Application for a non-material amendment following a grant of planning permission.

Single Storey Side Extension	
Reference number:	LU/71/21/HH
Date of decision	05/05/2021

Window size changes to front & rear elevations

Scale Bar 1:100

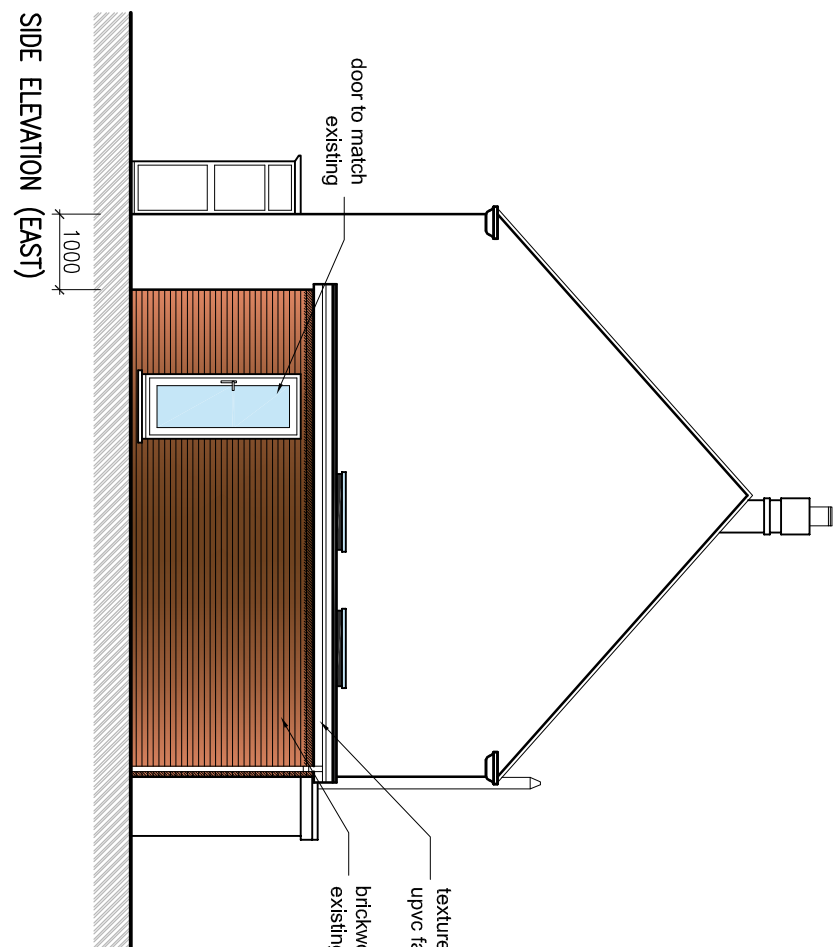
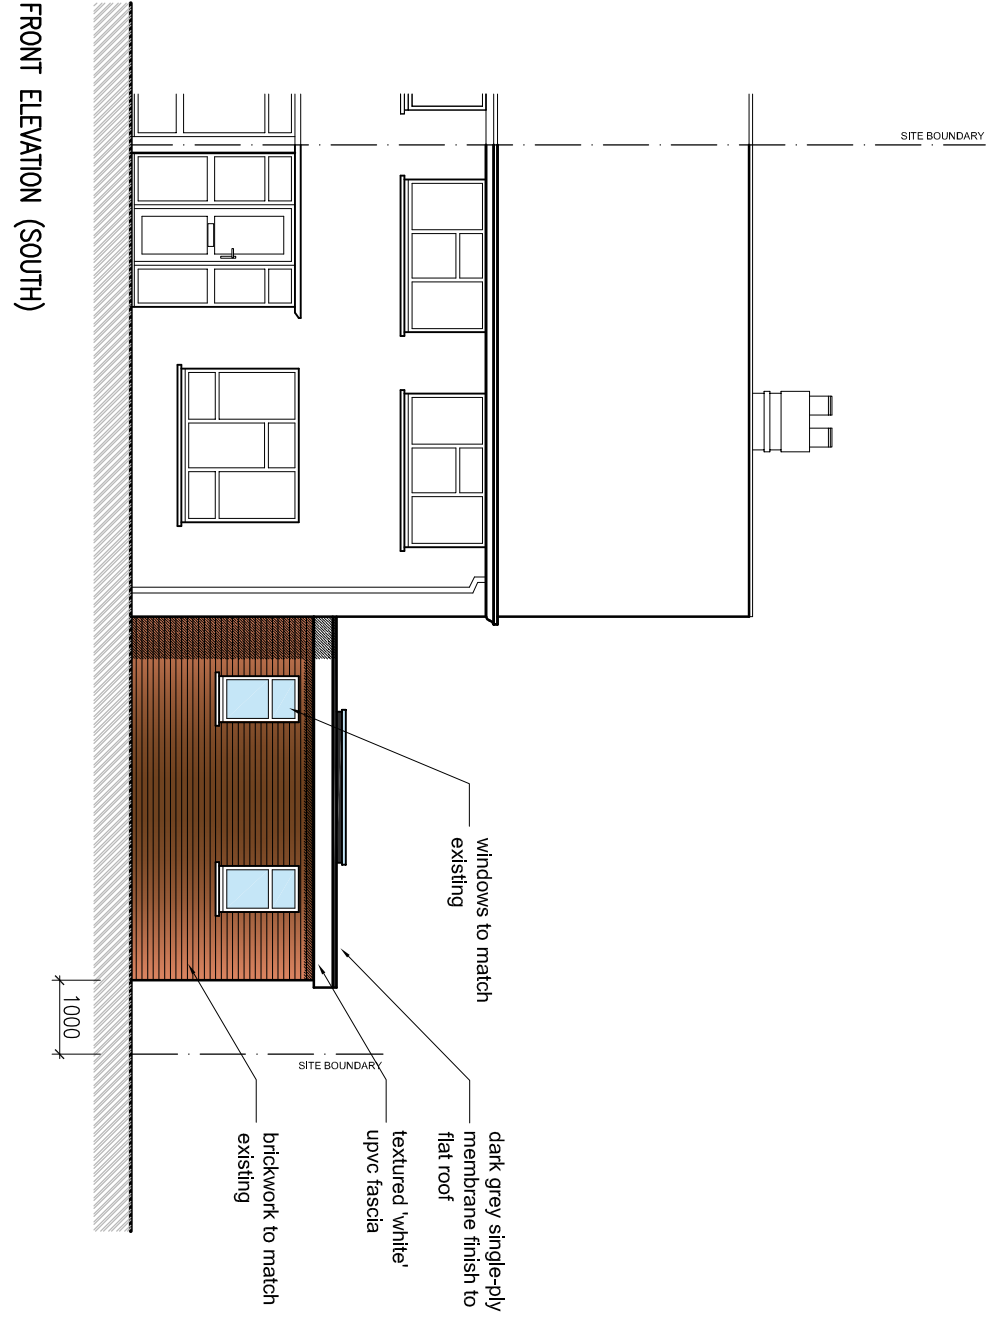
Internal layout changes

3353_12A_Proposed Floor Plans and Elevations
